From: Holly Duncan
Sent: Friday, February 22, 2013 3:18 PM
To: Jeff Watson; Dan Valoff
Subject: RE: Kittitas County Notice of Application

[AU-13-00001 Thayer](#)

Administrative Use Permit (Accessory Dwelling Unit)

Thayer ADU Permit  
 Site Map  
 2421 Judge Ronald Road  
 Ellensburg WA 98926

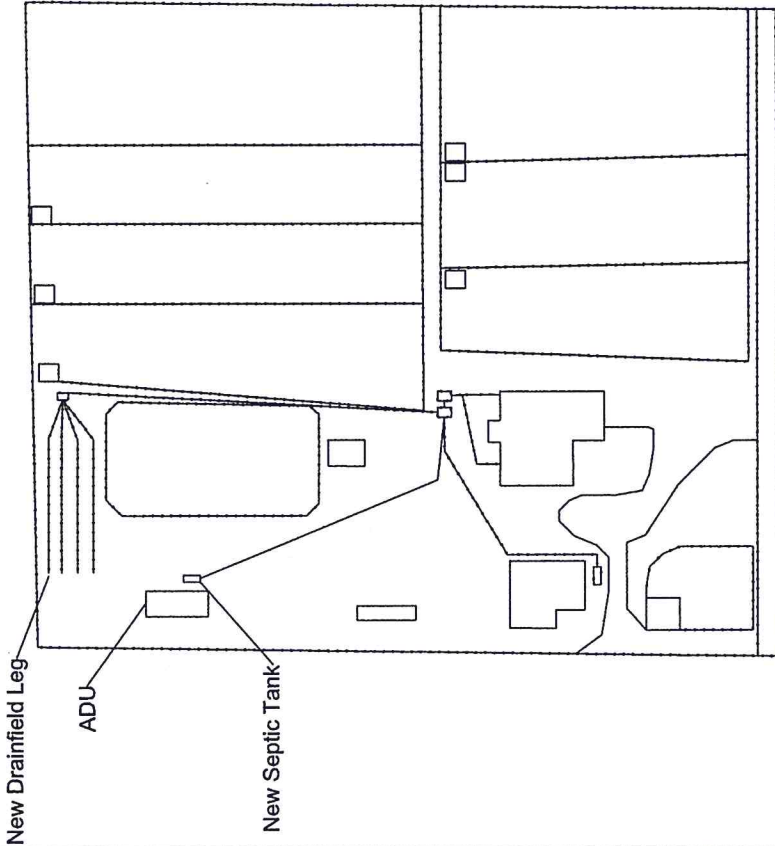
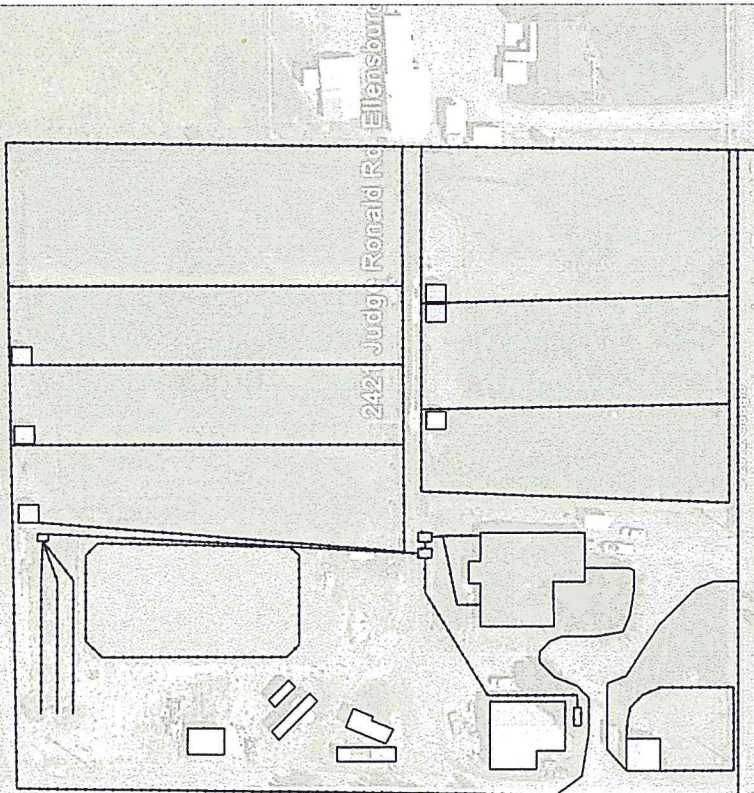
After reviewing this application, the proposed ADU looks like it will be the third house on the well. If this is actually the case, the well will need to be approved as a Group B well. The applicant will need to contact me to get a well site inspection done on the well to see if it meets all the requirements for a Group B source.
